**NORTH LINCOLNSHIRE COUNCIL**

# **LOCAL IMPACT REPORT**

**SUBJECT: APPLICATION FOR AN ORDER GRANTING DEVELOPMENT  
CONSENT FOR THE VPI IMMINGHAM OCGT PROJECT**

**Planning Inspectorate's Reference: EN010097**

Drawing file: EN010097 / EN010097-000271-6.3.24 - VPI OCGT - ES Figure 13.4 Indicative Areas of Archaeological Investigation.pdf

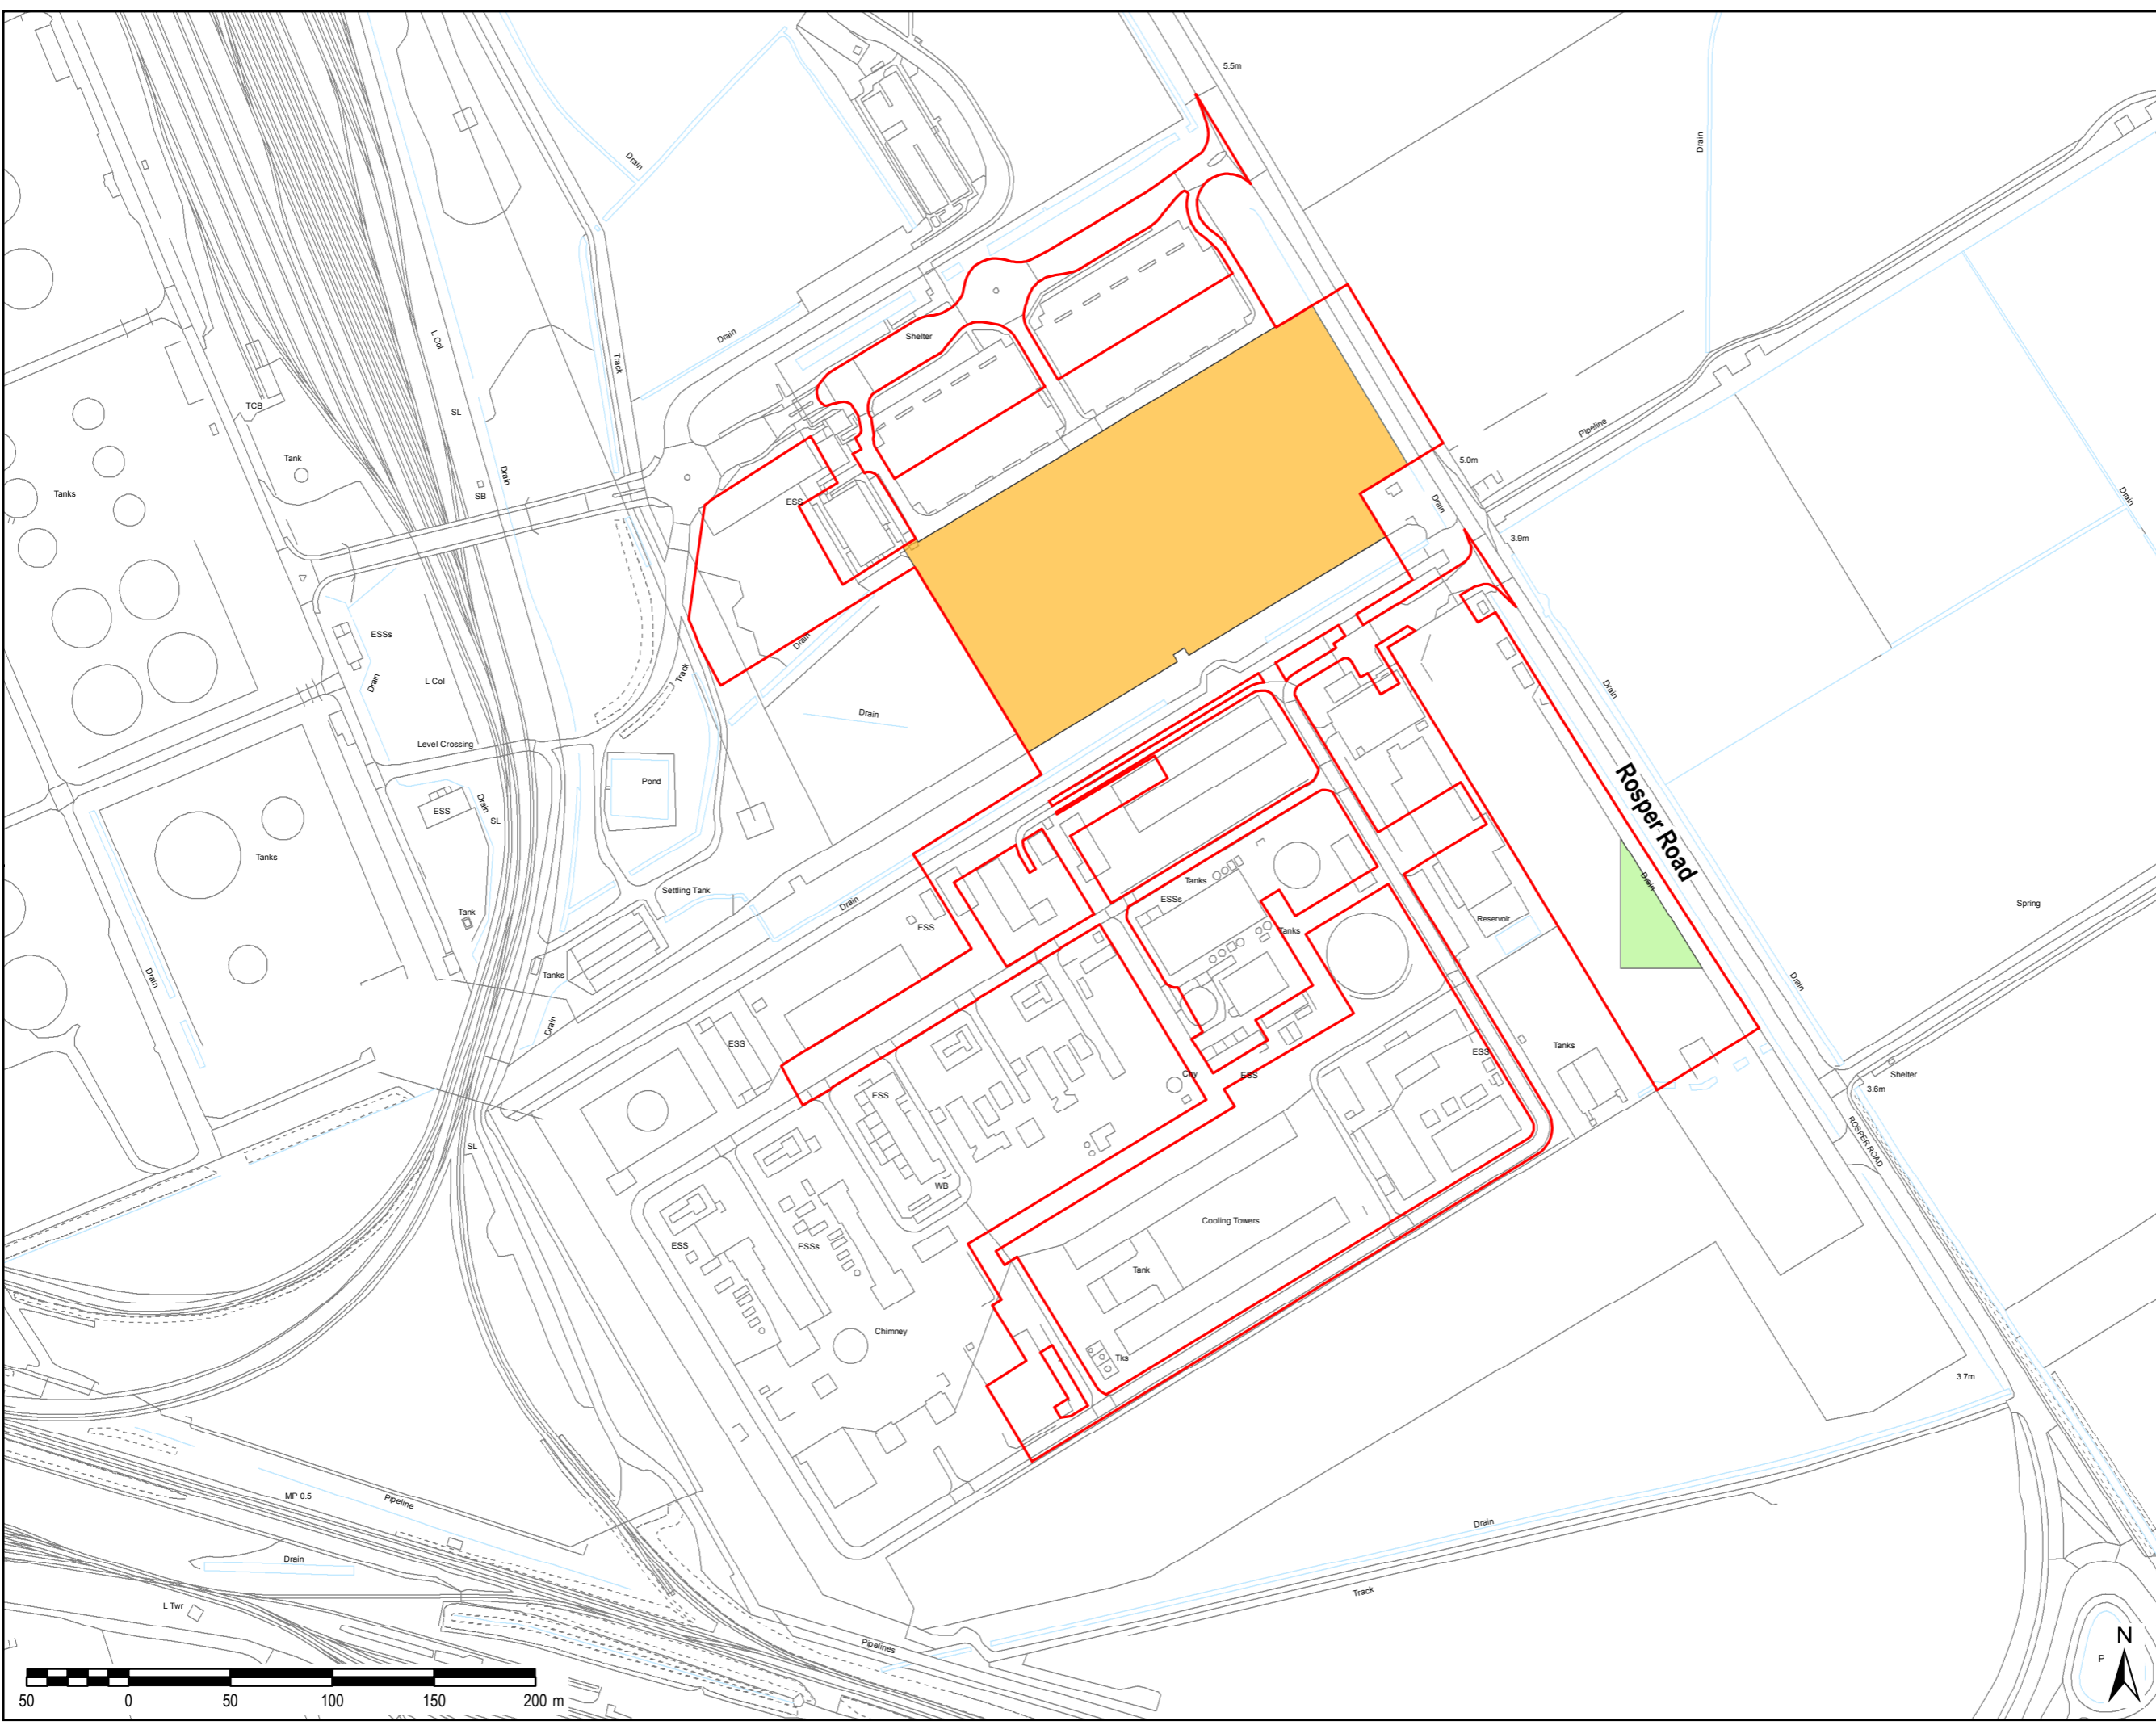
- 7.6 The proposed development will directly impact two non-designated heritage assets comprising areas of archaeological remains.
- 7.7 The first of these non-designated assets is within the Main OCGT site and comprises Iron Age ditches peripheral to the Iron Age settlement site excavated on the site of the CHP plant to the south (ES Figure 13.1, sites A17 and A6; Document Ref. 6.3.21).

- 7.8 Previous archaeological evaluation in 2006 identified these ditches. Soil mounded over this area from an adjacent development site has precluded further archaeological evaluation of the Main Site. Archaeological monitoring of the geotechnical ground investigations across the Main Site did take place but the extent of overburden largely compromised the archaeological observations (ES Appendix 13D Archaeology Report; Document Ref. 6.4.30). The heritage significance of the remains within the Main Site is their archaeological evidential value, and the potential of these and any associated remains to contribute to the understanding of the wider Iron Age settlement of this area.

- 7.9 The second non-designated asset is located within the temporary construction and laydown area running alongside Rosper Road (Work no.3). This comprises an area of Romano-British settlement features preserved in situ when the CHP plant was constructed.

- 7.10 These features are associated with the excavated Romano-British settlement site (ES Figure 13.1, site A6; Document Ref. 6.3.21). The preserved area is shown on ES Figure 13.4; Document Ref. 6.3.24. These preserved remains have high evidential value to contribute to the understanding of the character

- 7.15 With regard the proposed archaeological preservation in situ area within the construction and laydown area, the ES documents contain insufficient detail about how this area will be adequately protected during the construction, operation and decommissioning of the proposed development.

- 7.16 The use of this part of the site as a temporary construction and laydown area could have direct impact on the archaeological remains preserved in situ (hard standing, laydown and open storage areas, contractor compounds and staff welfare facilities, vehicle parking, roadways and haul routes, security fencing and gates, gatehouses, external lighting and lighting columns).

- 7.17 Mitigation measures to prevent any such damage will need to include robust permanent fencing and signposting around this area. These details should be provided in writing either combined with Framework WSI for the archaeological work on the Main Site, or as a separate written strategy. It is also important that the archaeological preservation area is clearly identified in the CEMP with an explanation of why and how this area is to be protected and monitored, and how this will be communicated to all those working on site.
